## PLANNING BOARD REPORT PORTLAND, MAINE

Studios at 46 Market Street  
46 Market Street  
Level III Site Plan and Subdivision Review  
2013-245  
Market Milk Partners, LLC, Applicant

Submitted to: Portland Planning Board Public Hearing Date: November 26, 2013 Planning Board Report Number: #55-13	Prepared by: Nell Donaldson, Planner Date: November 20, 2013 CBLs: 32-E-10001
---	---

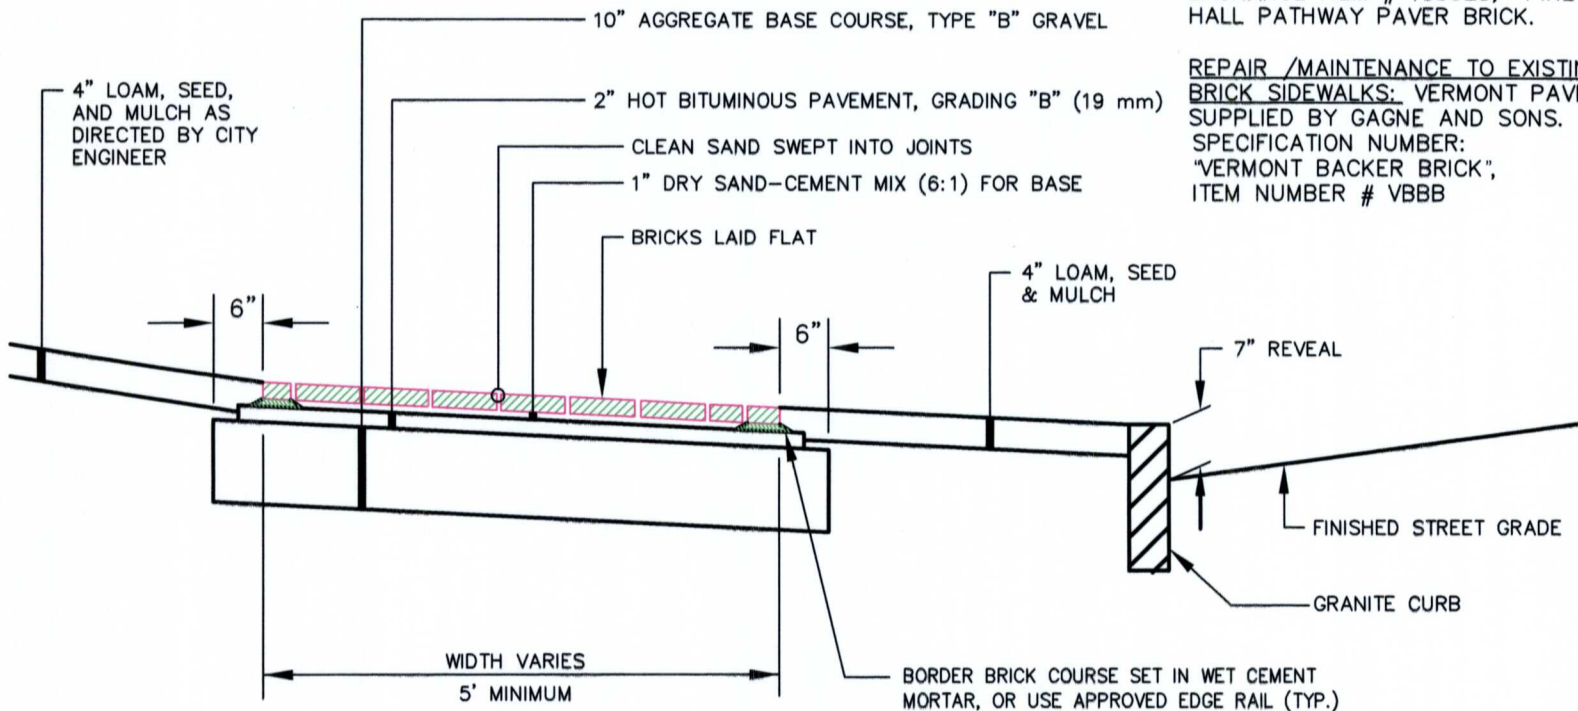
*The applicant is requested to re-build the sidewalk ramp at the corner of Milk and Market Streets installing a detectable warning panel for the historic district per Figure I-7A on page 40 of the City’s Technical Manual. The applicant is also request to install a short section of flush granite curb in conjunction with this ramp. The City may have a piece of granite curbing stored on outer Congress St which may be used at no cost to the applicant except to pick up and transport. The applicant is requested to use the Pinehall Pathway Pavers bricks when rebuilding this ramp.*

*There are two potential tripping areas in the Market St. sidewalk adjacent to sidewalk ramp. One next to the building corner and the other around the catchbasin headstone. The applicant is requested to remove the brick as necessary in these two areas and reconstruct as necessary to eliminate these tripping hazards. Again, the City may have bricks at the outer Congress Street storage area which will match the existing brick. The applicant is welcome to use these brick as necessary to facilitate these repairs.*

- 3. The applicant shall provide plans, stamped by a licensed engineer and including details, depicting:
  - a. The reconstruction of the ramp at Milk and Market Streets to include a standard detectable warning panel and flush granite curb,

- b. The reconstruction of areas of sidewalk on Market Street to eliminate tripping hazards, and
  - c. The installation of two bike parking spaces
 For review and approval by the city’s Department of Public Services; *and Planning Board Authority*
